MEMO

DATE	19.09.22	JOB	2808	PAGES	1 of 1
PROJECT	Trinity Grammar School SSD - Modification 04				
TO	Shaun Diamond				
COMPANY	Bloompark Pac				
FROM	Sue Cai				
REFERENCE	Response to Modification 04 RFI

Figure 8: Extract from modified Proposed Oval 3 Car Park B2.

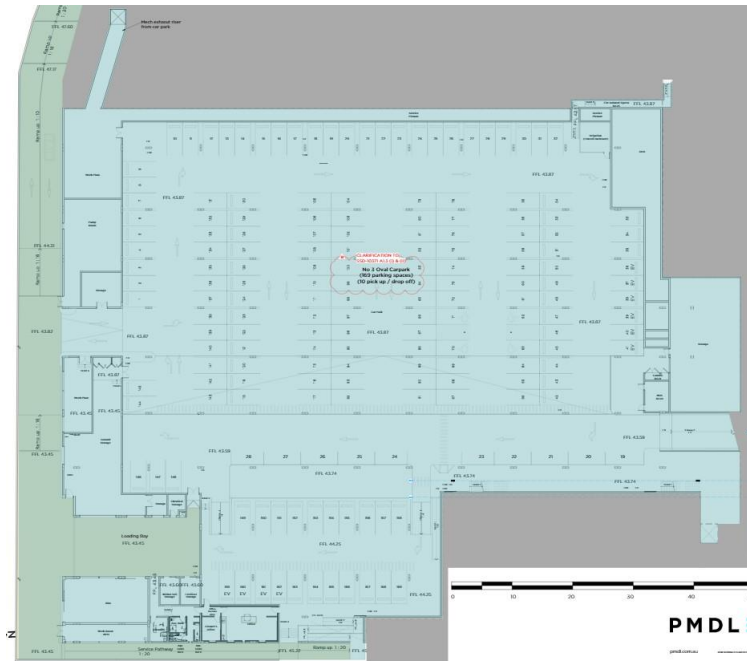
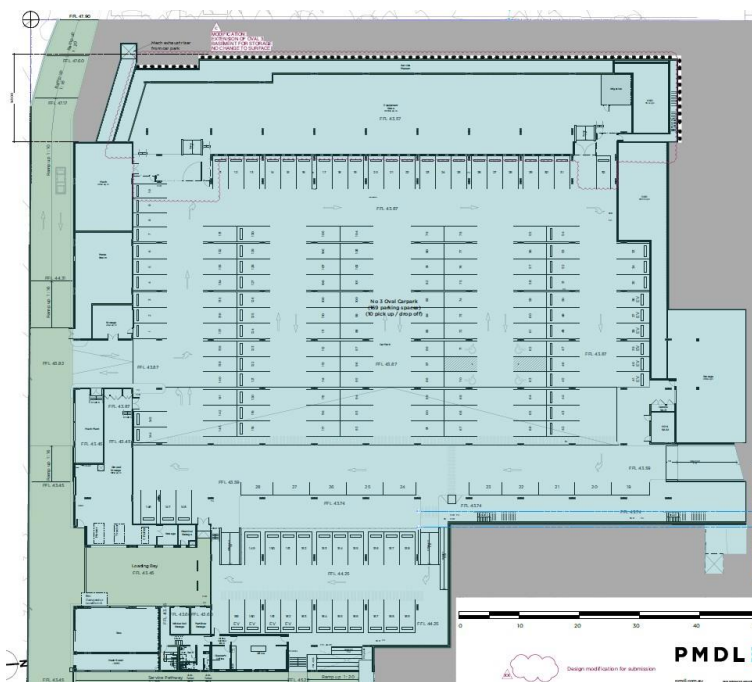
DPIE: Justify why a 300mm drop in floor level is required within the extended basement area.

The stormwater drainage from Oval 3 sports field will fall towards the western plenum in the carpark, where the pipe enters and gets directed to the OSD tank. Due to the extended length and fall, and the school's need maintain 2300mm clearance. The slab in this extended area is dropped by 300mm.
